COMMUNITY DEVELOPMENT DEPARTMENT
80 Columbia Avenue ♦ Marysville, WA 98270
(360) 363-8100 ♦ (360) 651-5099 FAX

April 27, 2022

Re: Undi Commerce Park – *Technical Review 1*
PA 22008

RE: Undi Commerce Park, File# PA22-008
Approximately 815,484 SF of tilt up warehouse space
14407, 14511, 14525, 14607, 14621, 14715 & 14725 Smokey Point Blvd.
Parcel's # 31053300302500, 31053300302300, 31053300301900, 31053300302700,
31053300300300, 31053300300900, 31053300301000, 31053300300500, 31053300302200,
31053300303000, 31053300303100, 31053300301100, 31053300302600, 31053300301200

sheet
A1.2

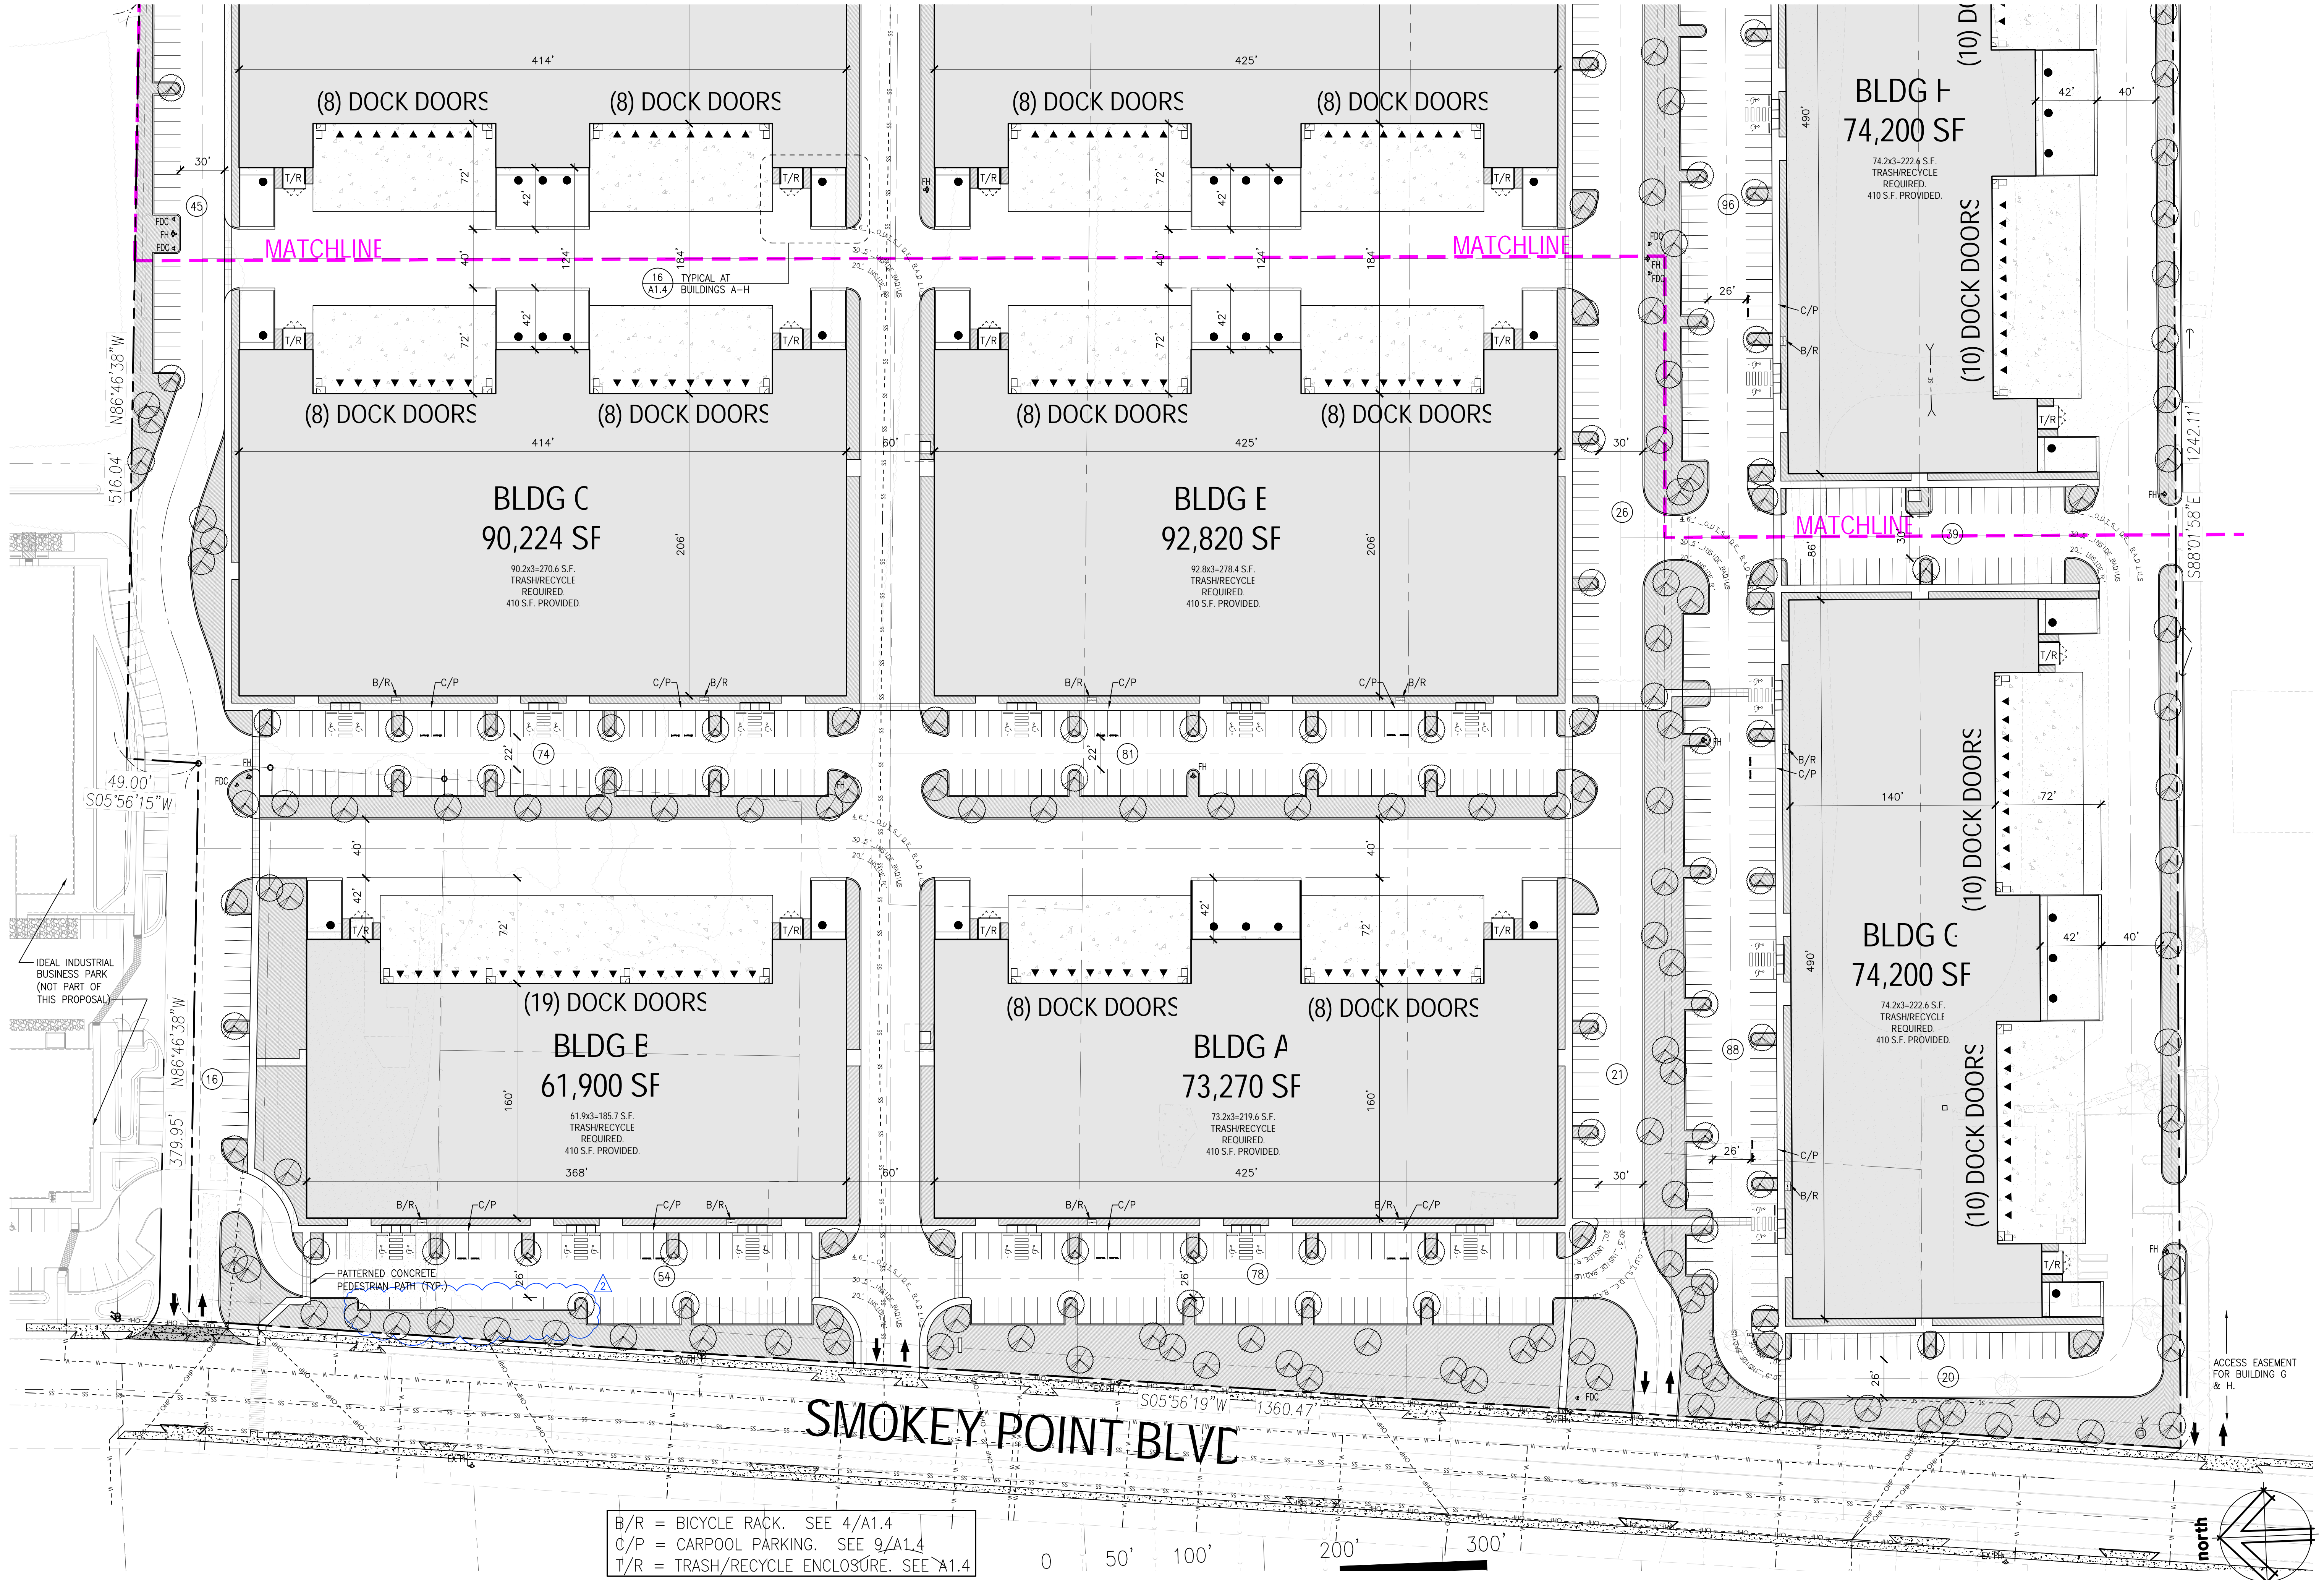
5. Sheet A0.1 – Overall Site Plan, shall be amended, as follows:
 - a. Pursuant to [MMC 22G.120.060](#)(3)(b), provide additional sheets at a reviewable scale (i.e. 1" = 20', 1"= 30', 1"= 40' or 1" = 50').

- b. The site plan shall be revised to comply with EDDS 3.301 *Arterial Access Management Standards*. See attached comments from Kacey Simon, Civil Plan Reviewer, dated April 14, 2022 and Jesse Hannahs, PE, Traffic Engineering Manager, dated April 27, 2022.

- e. Thank you for referencing the minimum turning radii on the site plan. Depict actual turning radii proposed on site plan.
- f. Provide an auto-turn exhibit showing that the largest trucks navigating through the site will not damage any vertical curbs and landscape islands.
- g. Additional pedestrian connections traversing the proposed drive-aisles and in some instances landscape buffers, shall be provided per the attached redlines

6 TRASH/RECYCLE ENCLOSURE
Scale: 1/8"=1'-0"

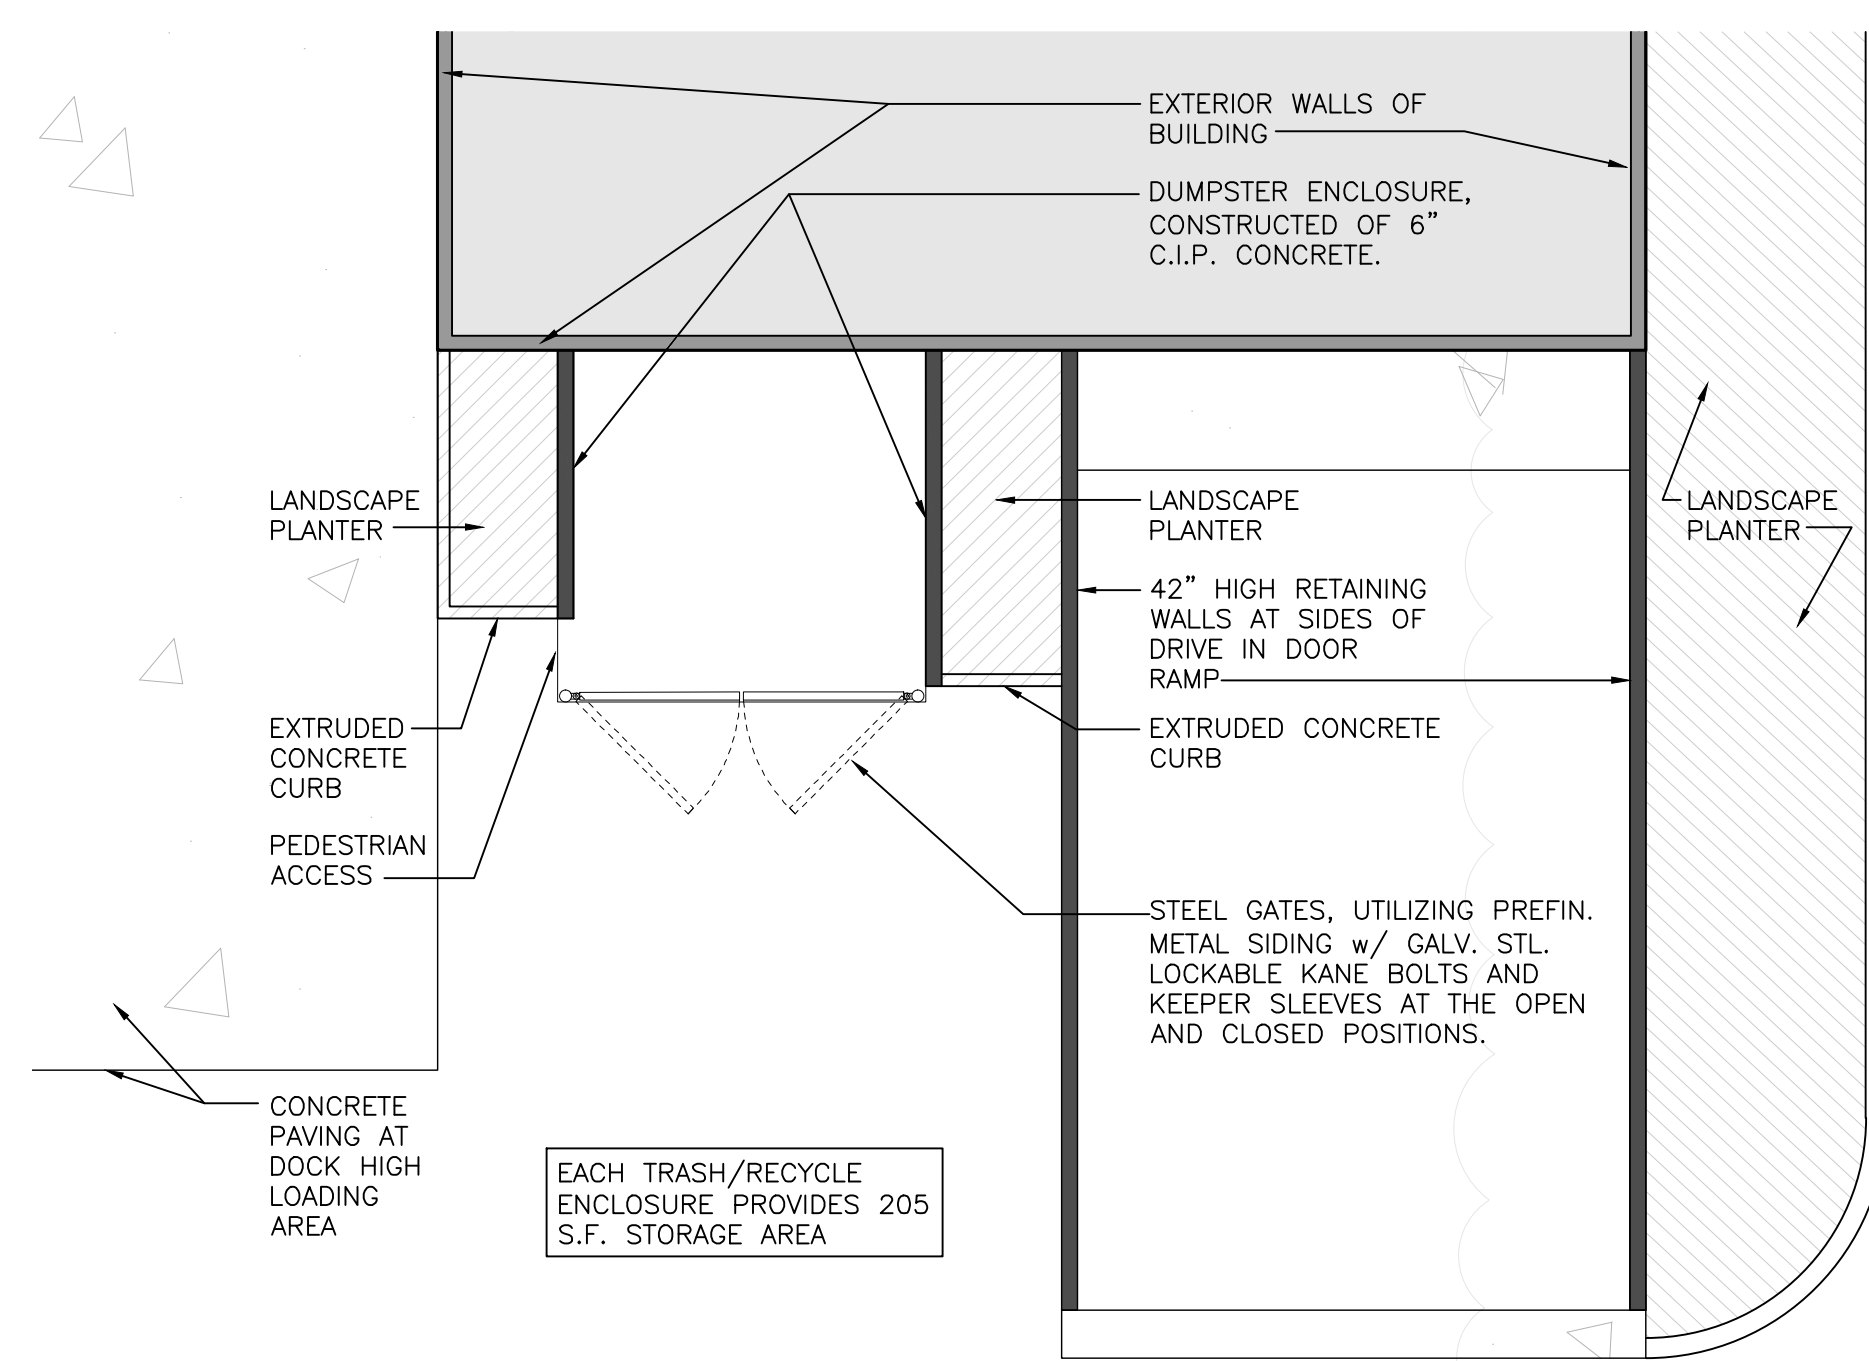
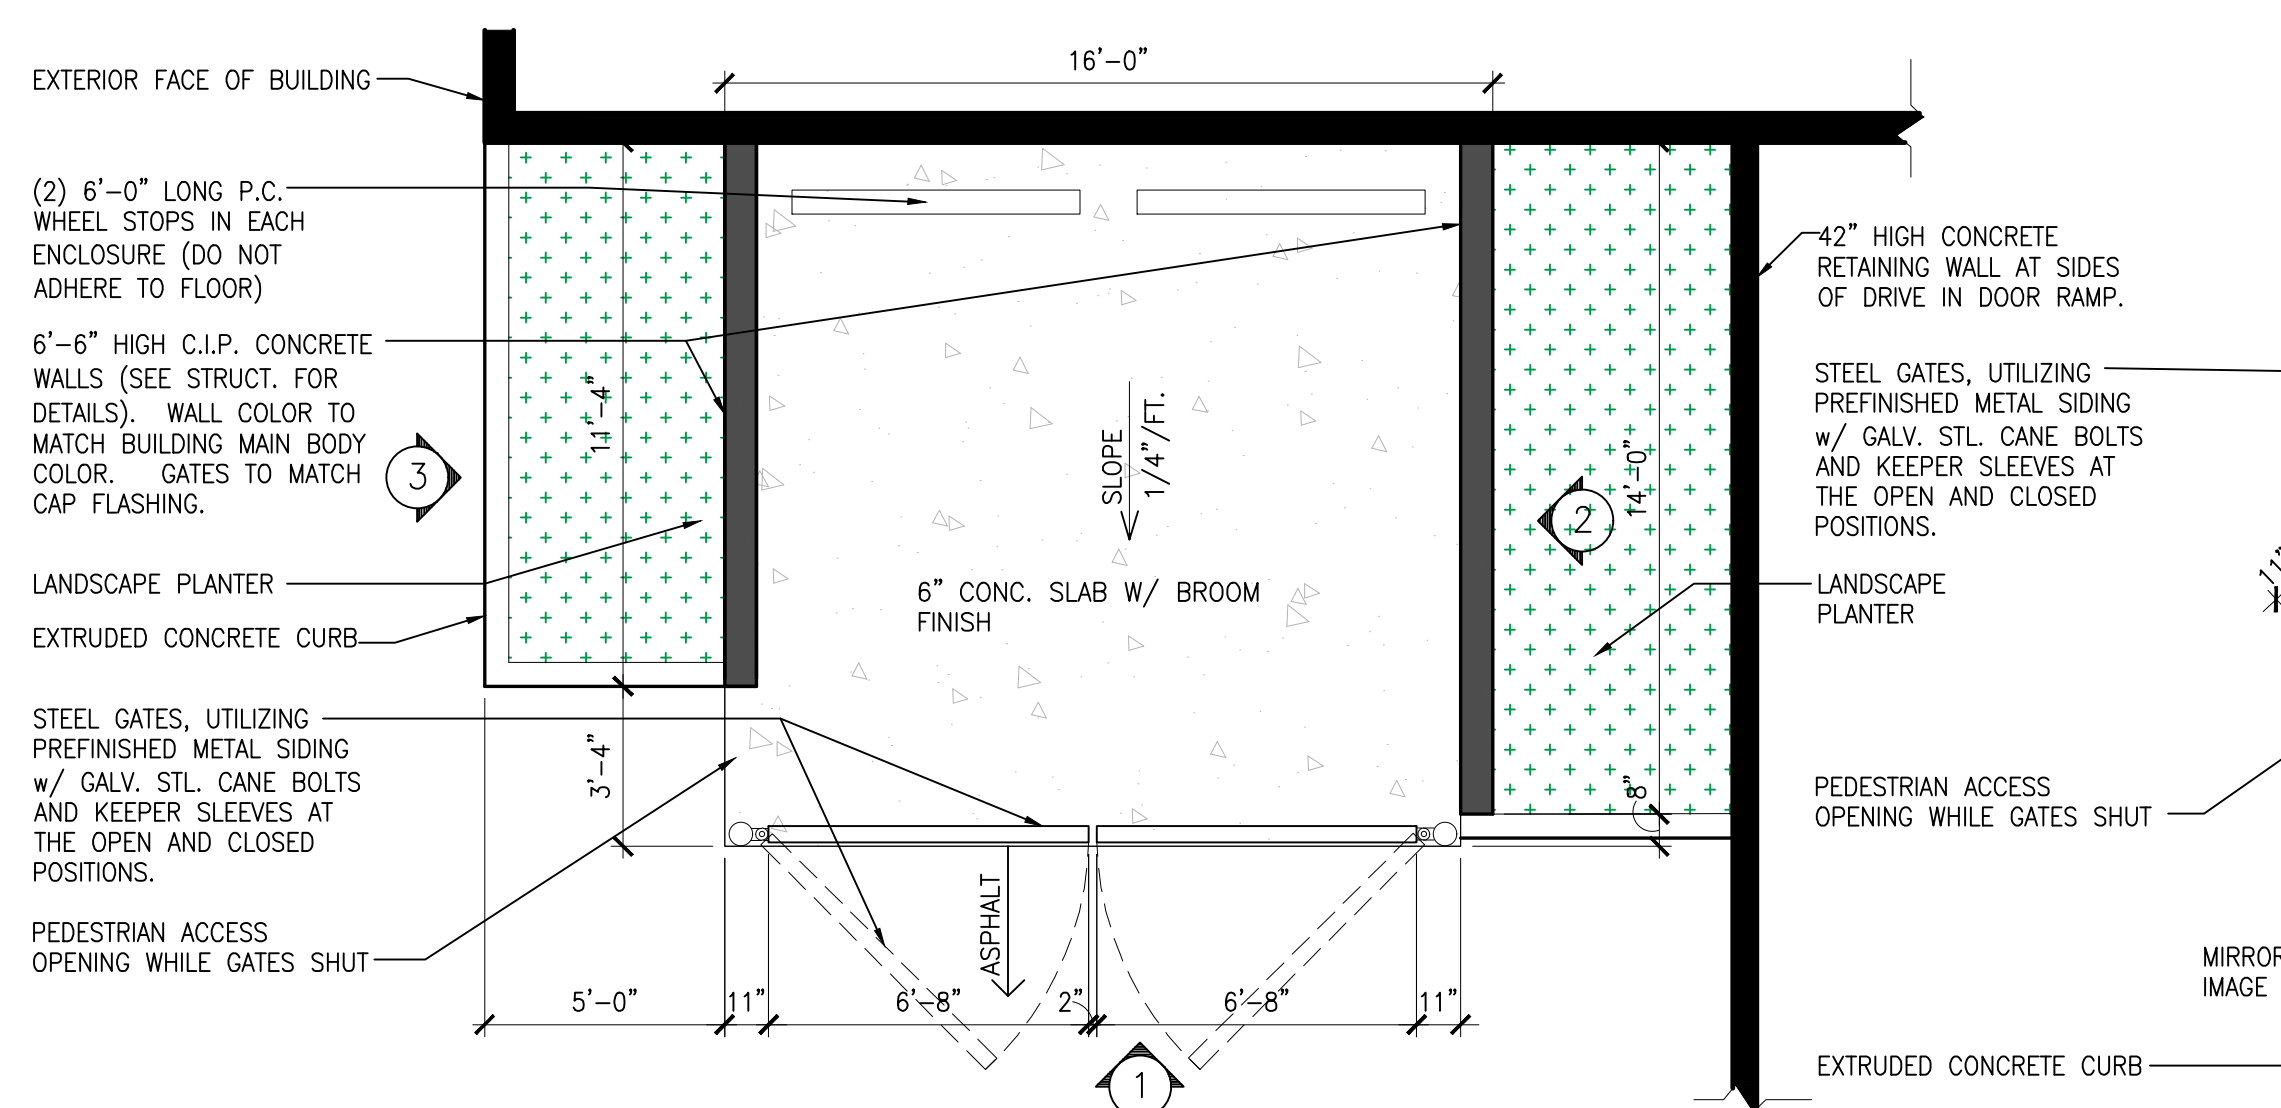
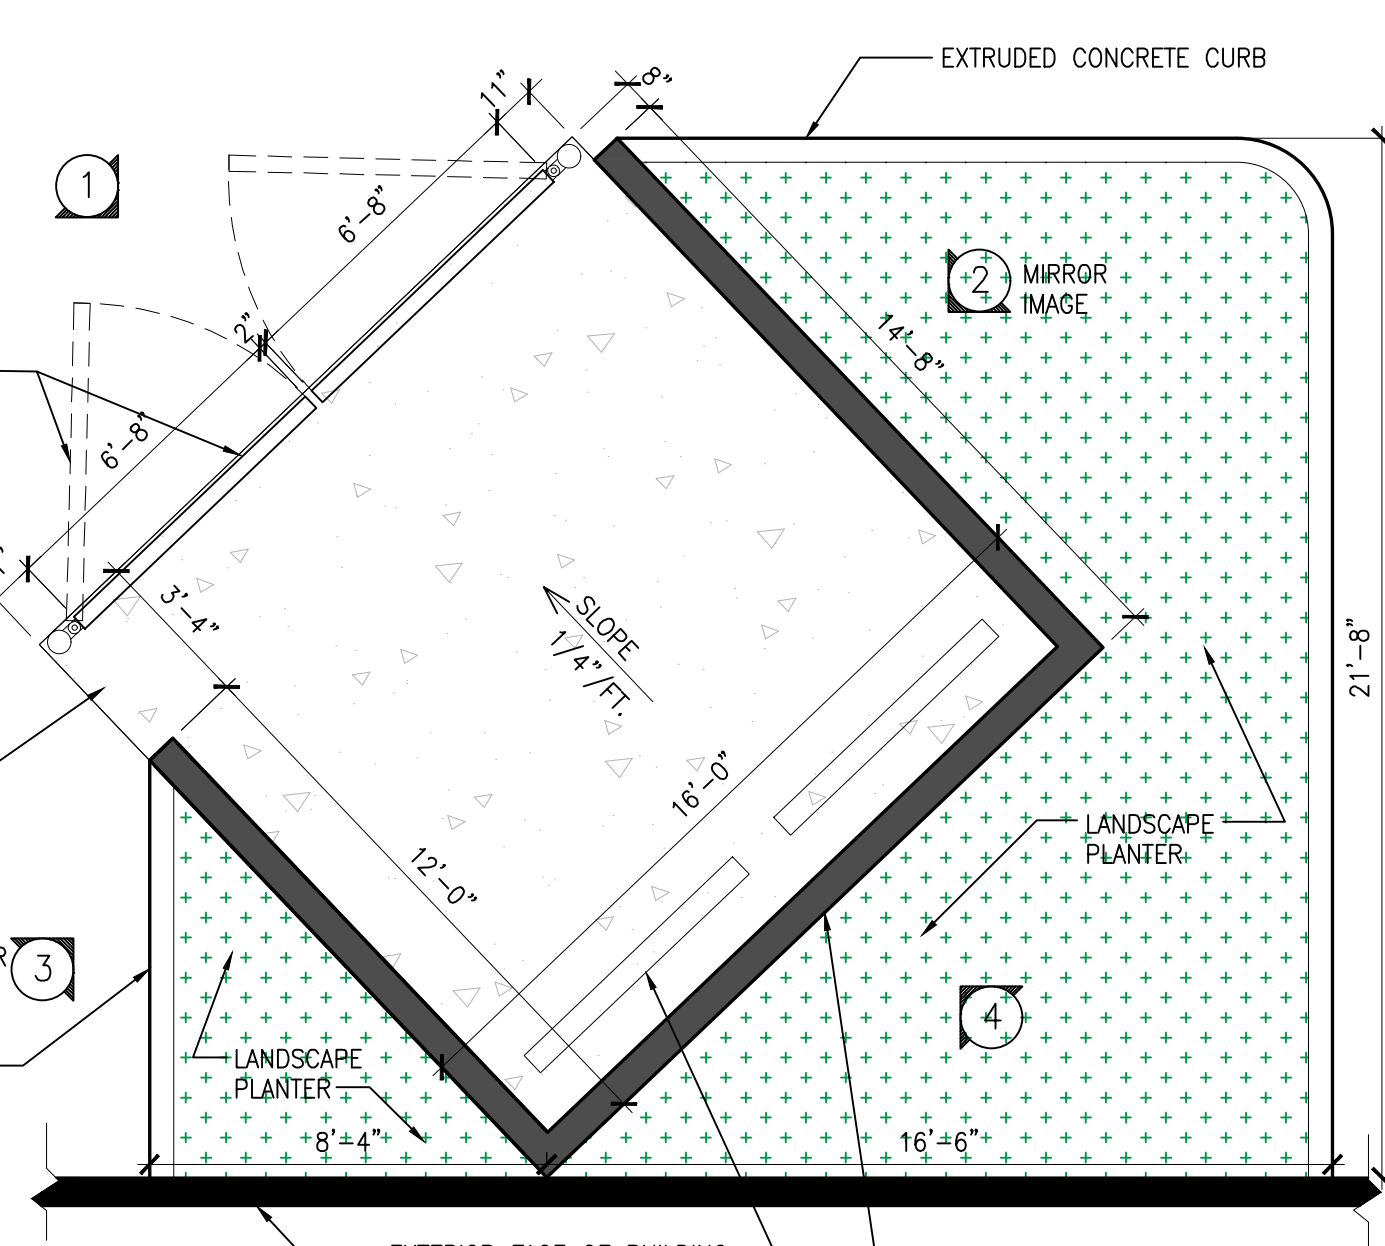
- c. Provide storage space and collection points for recyclables in accordance with [MMC 22C.020.320](#). Additionally, note the required SF calculations on the site plan, including area provided. This is in addition to the solid waste collection areas below.

Collection areas are required to be paved with concrete and screened with a minimum 6' high enclosure constructed of concrete block or brick, in addition to the landscaping provisions outlined below.

- d. Provide collection points for solid waste. Contact Skip Knutsen, Public Works Service Manager, at 360.363.8173 or sknutsen@marysvillewa.gov, for solid waste collection area dimensional and location criteria.

Collection areas are required to be paved with concrete and screened with a minimum 6' high enclosure constructed of concrete block or brick, in addition to the landscaping provisions outlined below.
